West Yorkshire Police
Kirklees District

Designing Out Crime Officer

To: Nick Hirst Kirklees Council Planning Services Civic Centre 1, High Street, Huddersfield, HD1 2NF	Ref: 2020/93994 Date: 1 st February 2021
---	--

Site Location: Globe Mills, Bridge Street, Slaithwaite, Huddersfield, HD7 5JN
Application: Variation of Condition 27 on previous 2015/90646 application

Proposed Footbridge  
General Arrangement

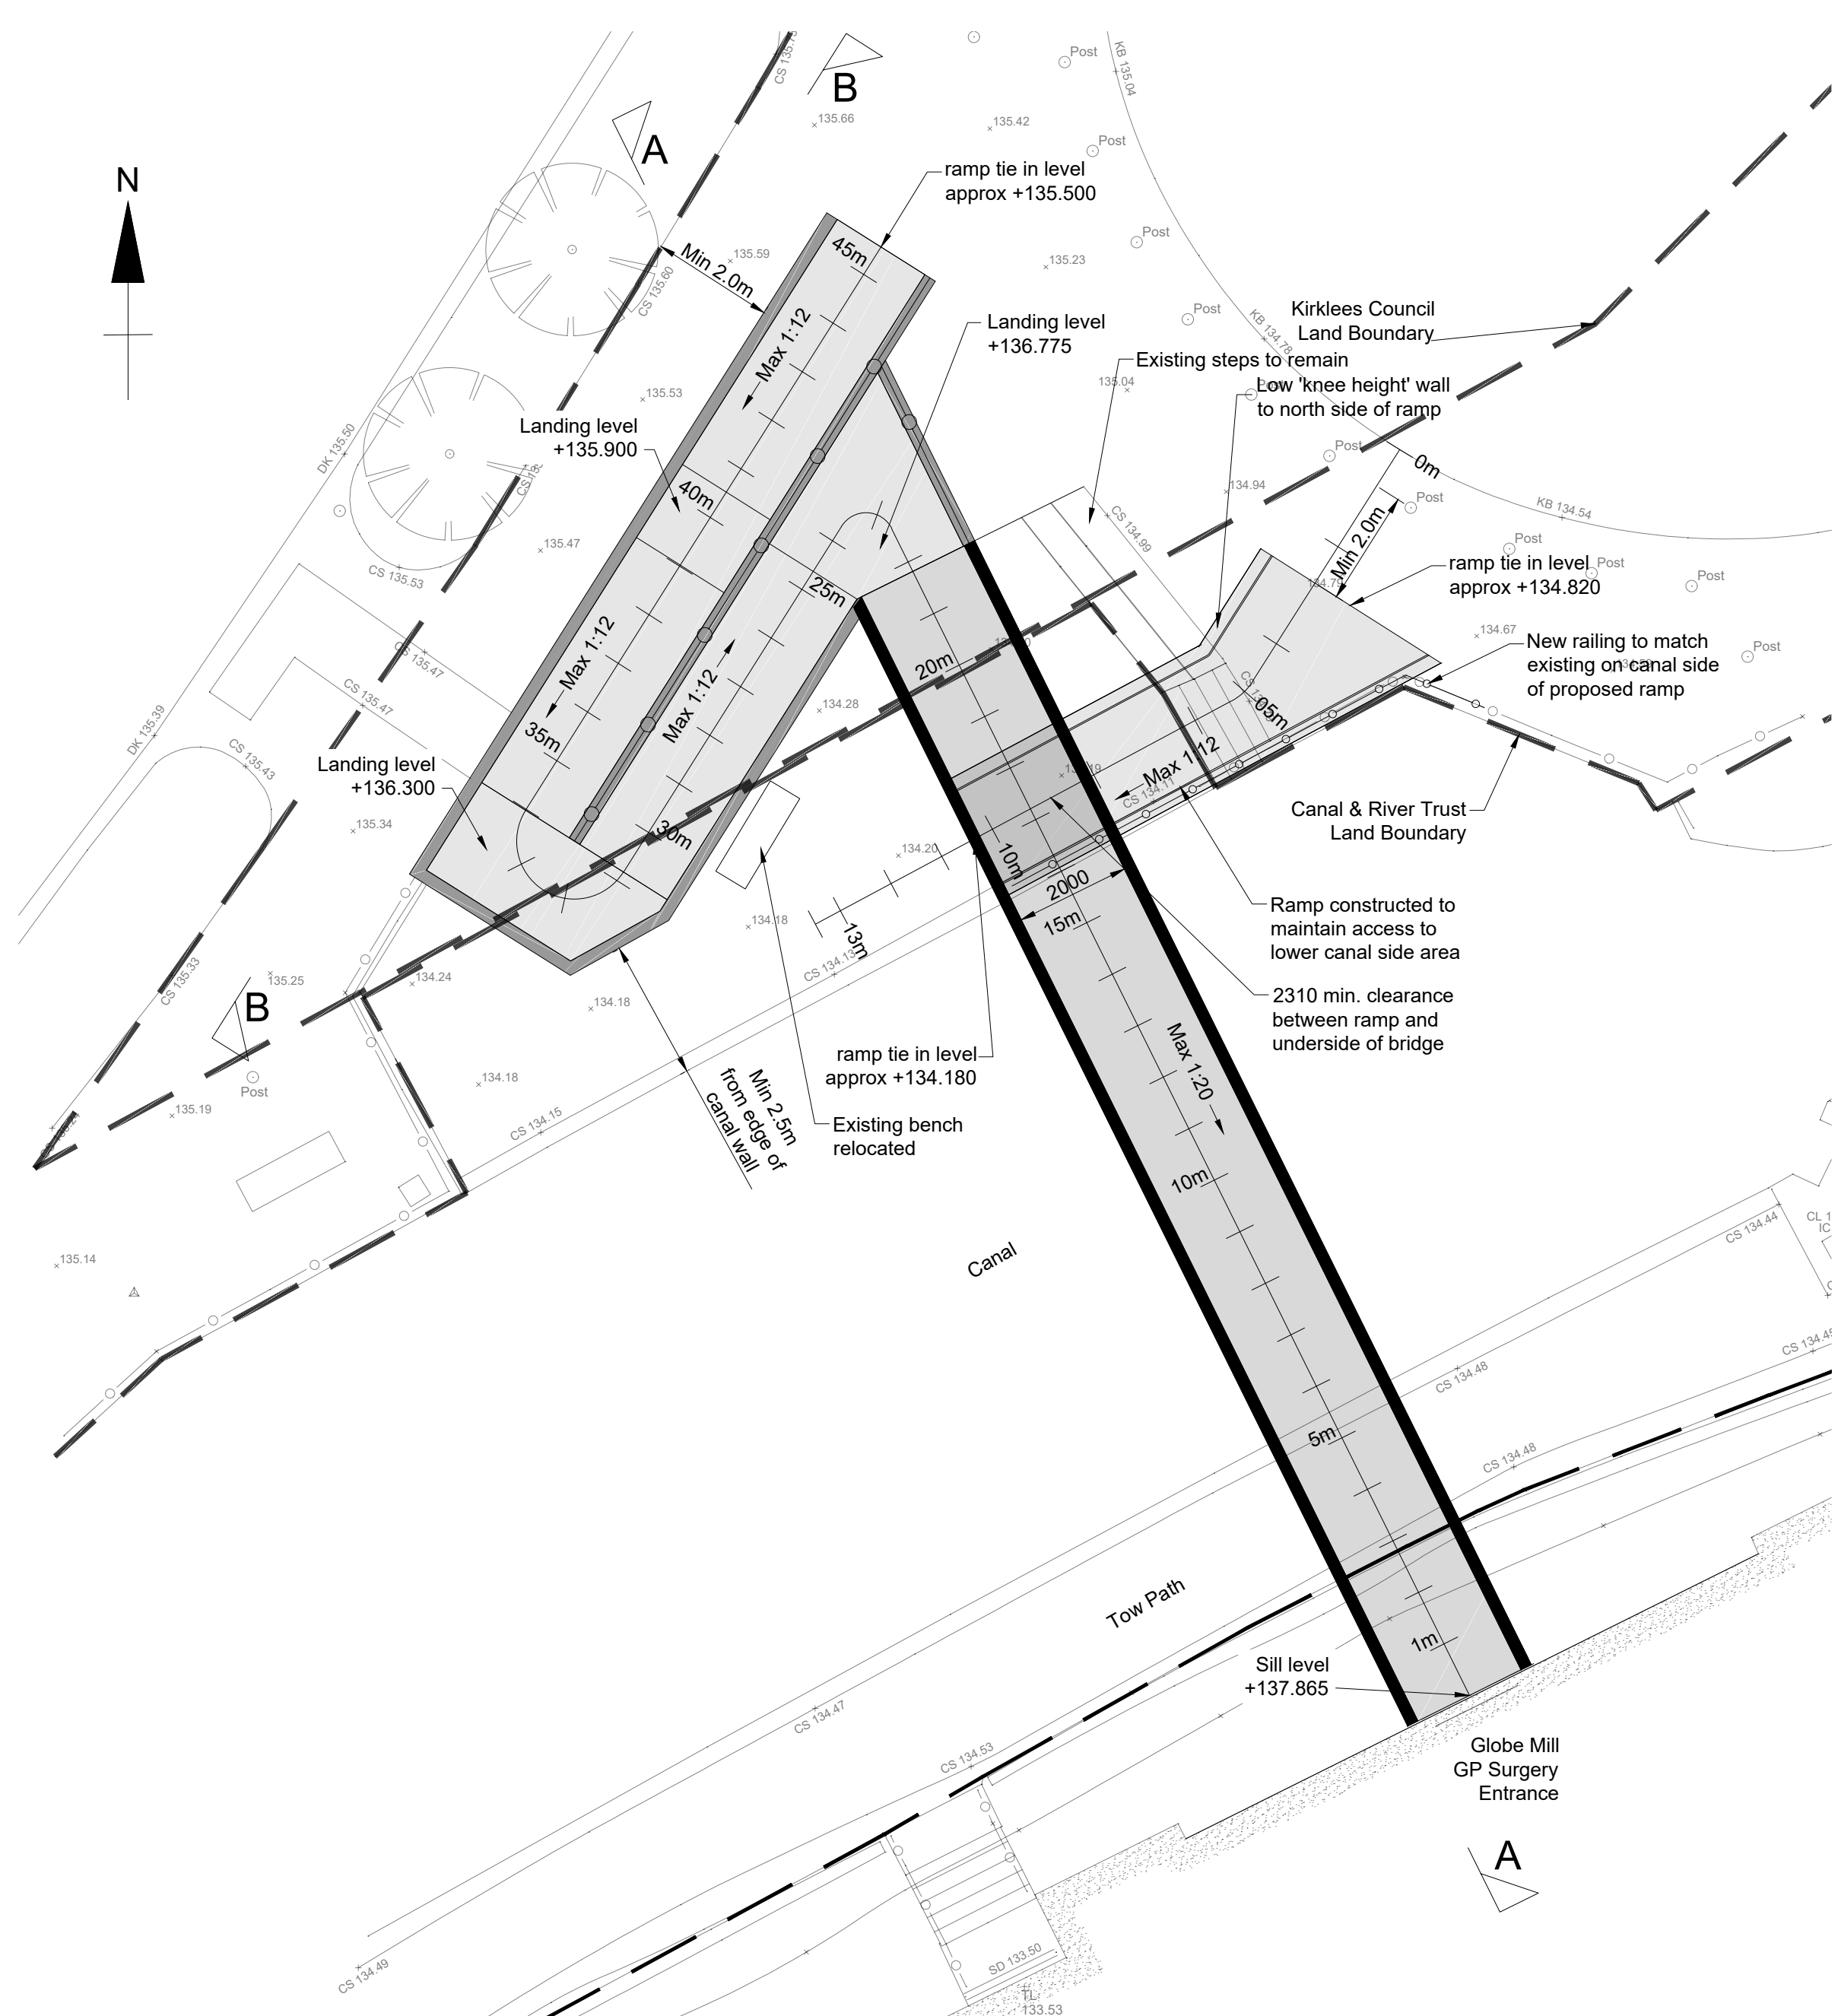
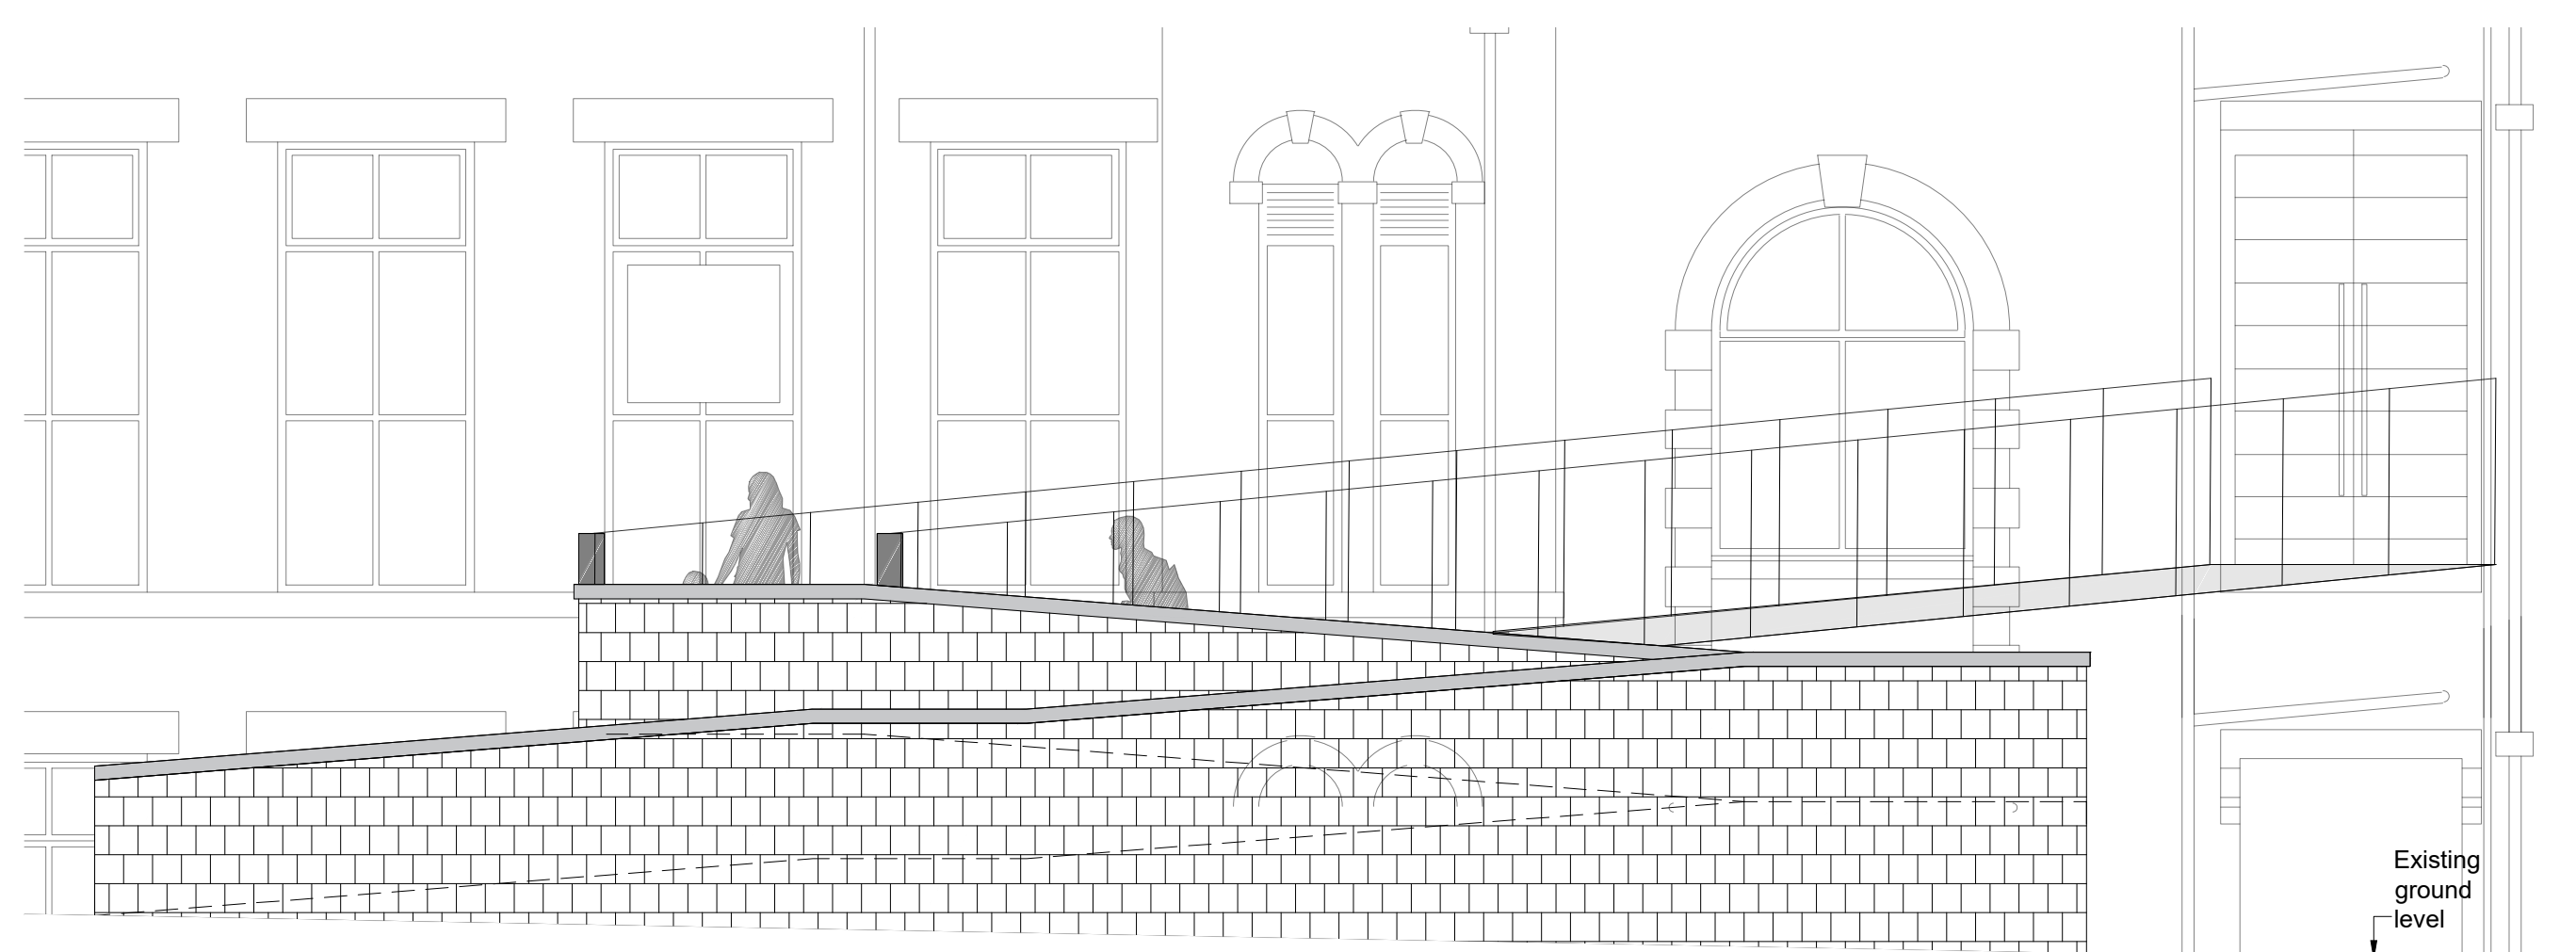
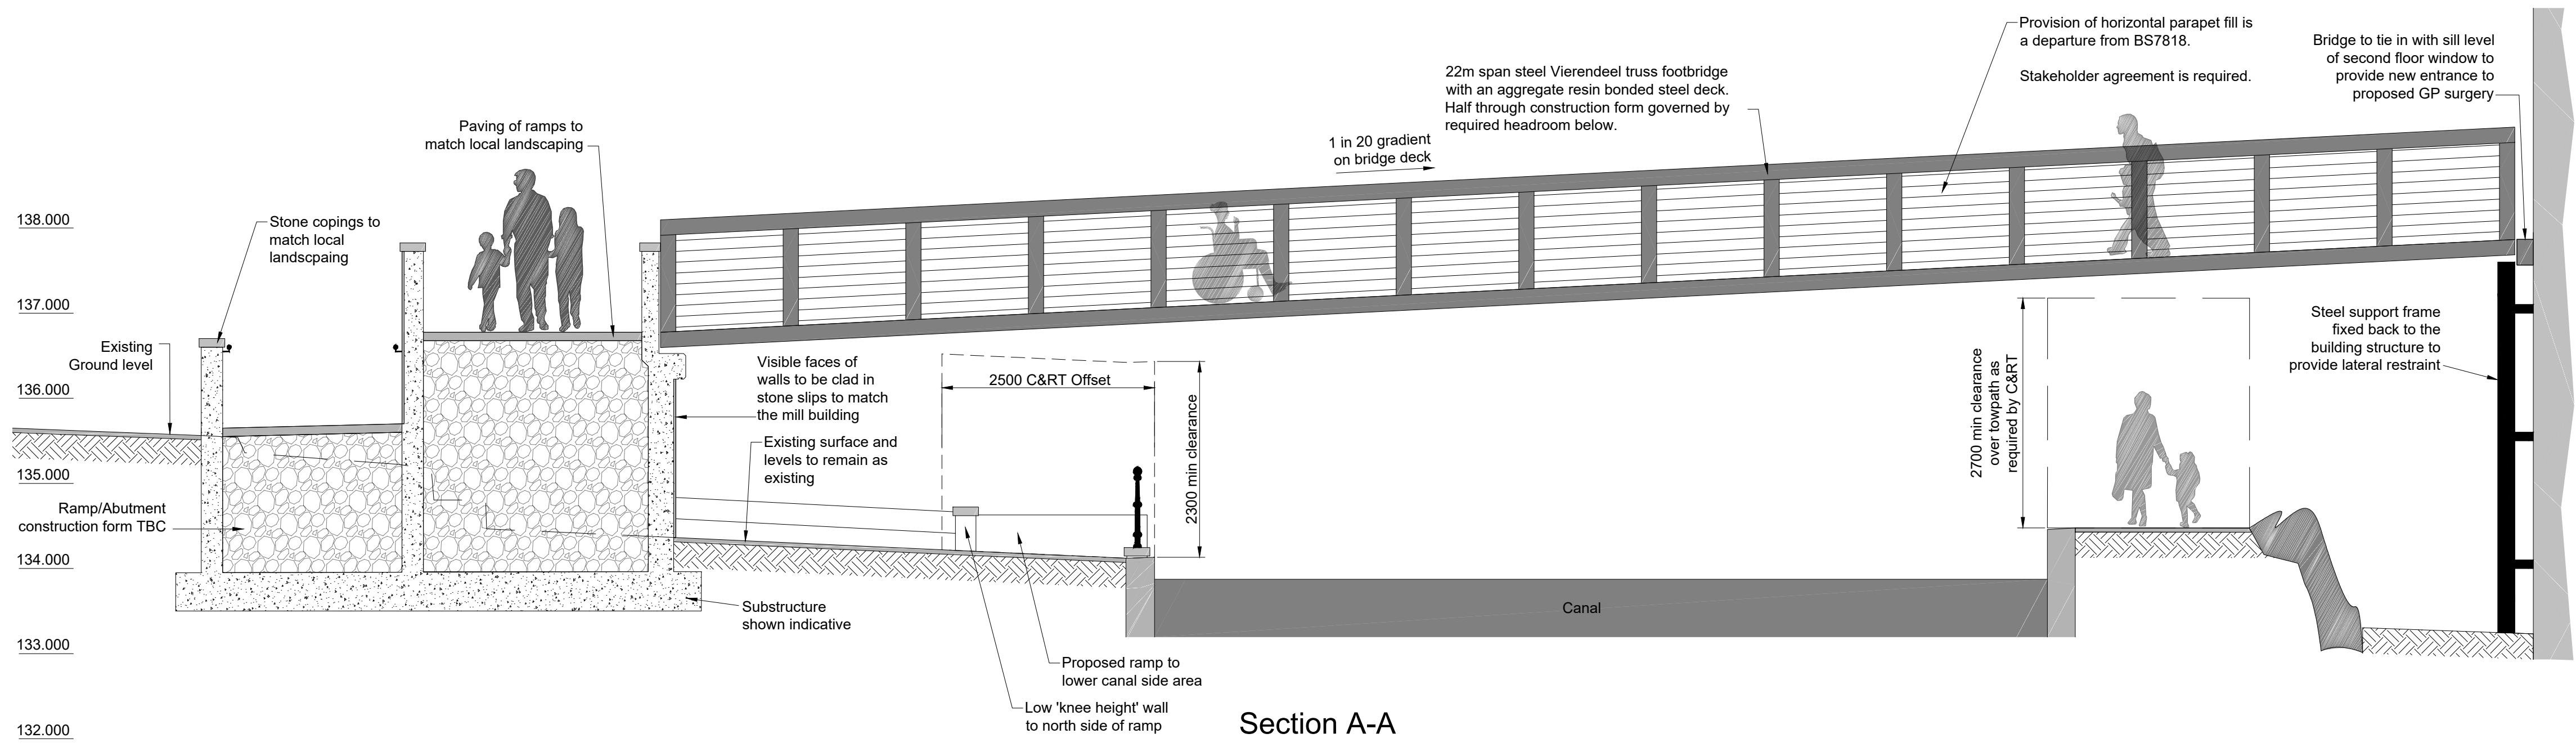
The footbridge should be designed so that the space below is not attractive for people to gather and cause anti-social behaviour.

Appropriate lighting to BS5489-1:2020 standard must be installed to allow for good night time visibility on the bridge to deter loitering.
